REQUEST

Current Zoning: B-1(CD) (general business, conditional)
Proposed Zoning: O-1(CD) (office, conditional)

Approximately 1.04 acres located at the northwest intersection of Carmel Road and Little Avenue, north of Pineville-Matthews Road, and east of Johnston Road.

The petition proposes redevelopment of the parcel with a new 17,200 sq ft, 2 story building allowing all uses permitted in the O-1 zoning district in south Charlotte, just north of the Carmel Commons shopping center.

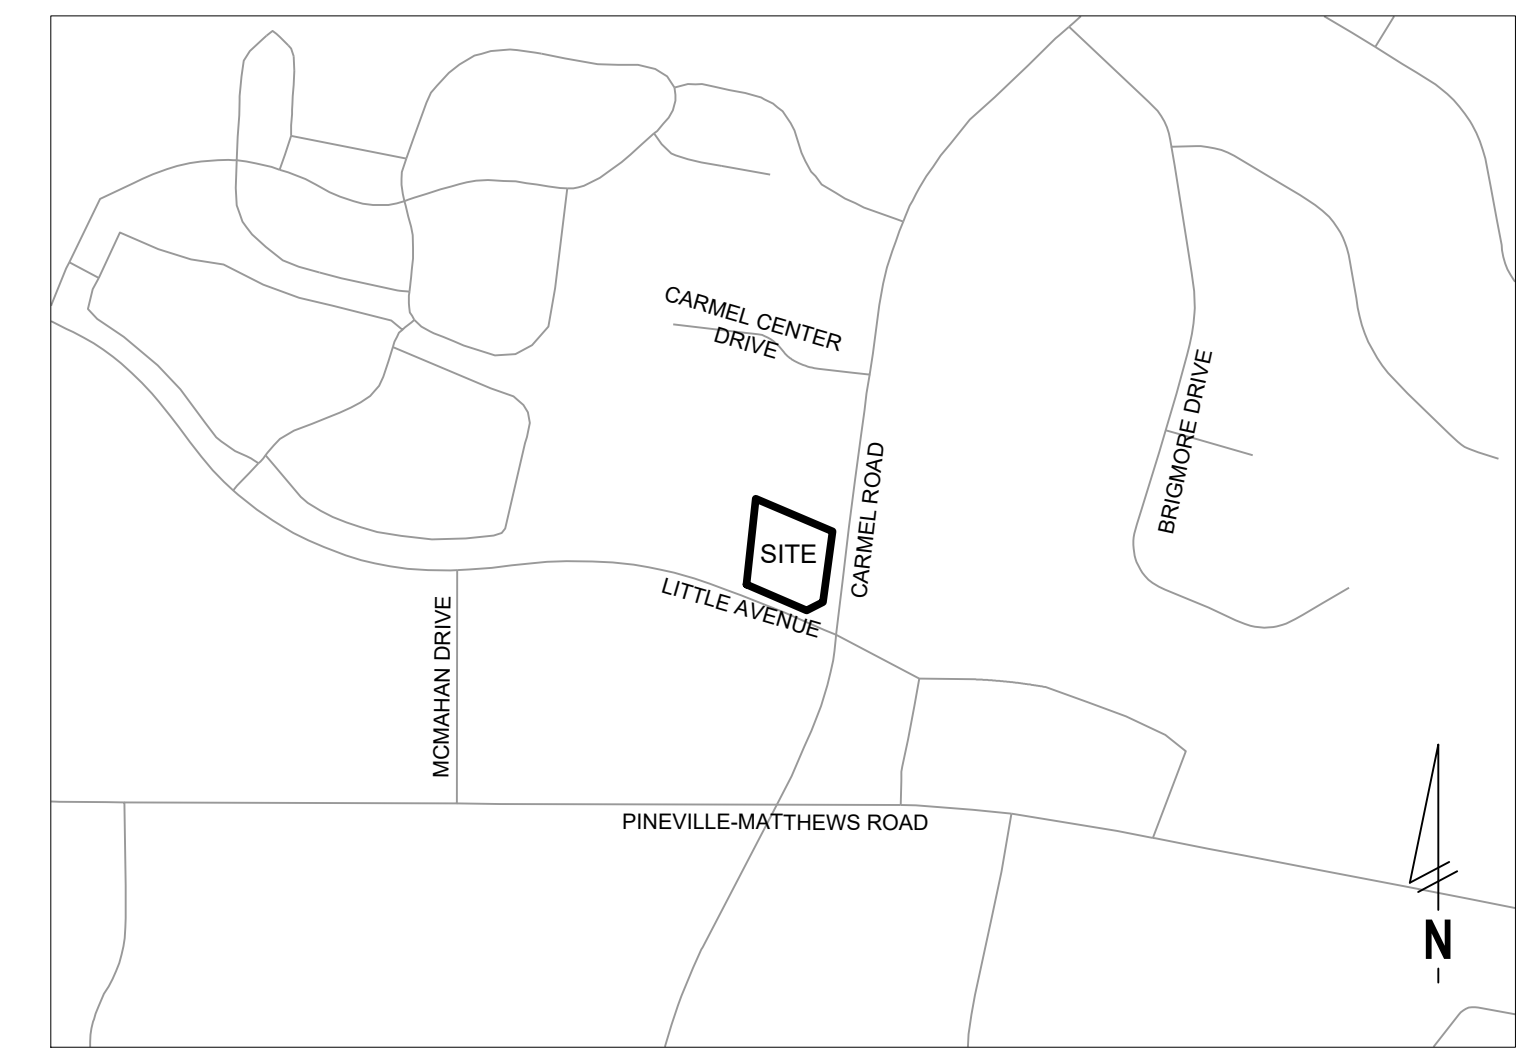
1. Incorporate architectural design standards as provided by Urban Design staff.
 - o Facades fronting streets shall include a combination of windows and operable doors for a minimum of 60% of each frontage elevation transparent glass between 2' and 10' on the first floor. Up to 20% of this requirement may be comprised of display windows. These display windows must maintain a minimum of 3'-0" clear depth between window and rear wall. Windows within this zone shall not be screened by film, decals, and other opaque material, glazing finishes or window treatments. The maximum sill height for required transparency shall not exceed 4'-0" above adjacent street sidewalk.

- o The facades of first/ground floor of the buildings along streets shall incorporate a minimum of 30% masonry materials such as brick or stone.
 - o Direct pedestrian connection should be provided between street facing doors, corner entrance features to sidewalks on adjacent streets.

- o Building elevations shall not have expanses of blank walls greater than 20 feet in all directions and architectural features such as but not limited to banding, medallions or design features or materials will be provided to avoid a sterile, unarticulated blank treatment of such walls

- o Building elevations shall be designed with vertical bays or articulated architectural features which shall include a combination of at least three of the following: a combination of exterior wall offsets (projections and recesses), columns, pilasters, change in materials or colors, awnings, arcades, or other architectural elements.

- o Multi-story buildings should have a minimum of 20% transparency on all upper stories.
2. Clarify if parking will be present under the building below grade or podium. If podium, the building should present ground floor active use along the public street fronts.

3. Add a note that no parking and maneuvering will be located between the building and street.

4. Adjust the site plan to show the back of curb and gutter along Carmel Rd at 33ft from the centerline to accommodate the Charlotte Streets Map with a roadway typical section of CLDSM 11.09 Major Thoroughfare. (Site plan currently shows 32 ft from centerline.)

5. Remove layers showing existing development or move the existing development information to a separate sheet.
6. Label and dimension the 12 ft multi-use path and 8 ft planting strip shown along Carmel Rd. and label and dimension the existing planting strip and sidewalk along Little Ave.
7. Add a note committing to the construction of the 8 ft planting strip and 12 ft multiuse path.
8. Add a note committing to the provision of the 14 ft Class C buffer that is shown on the site plan.

9. Label and dimension the curb and gutter from the centerline of each road on the site plan.
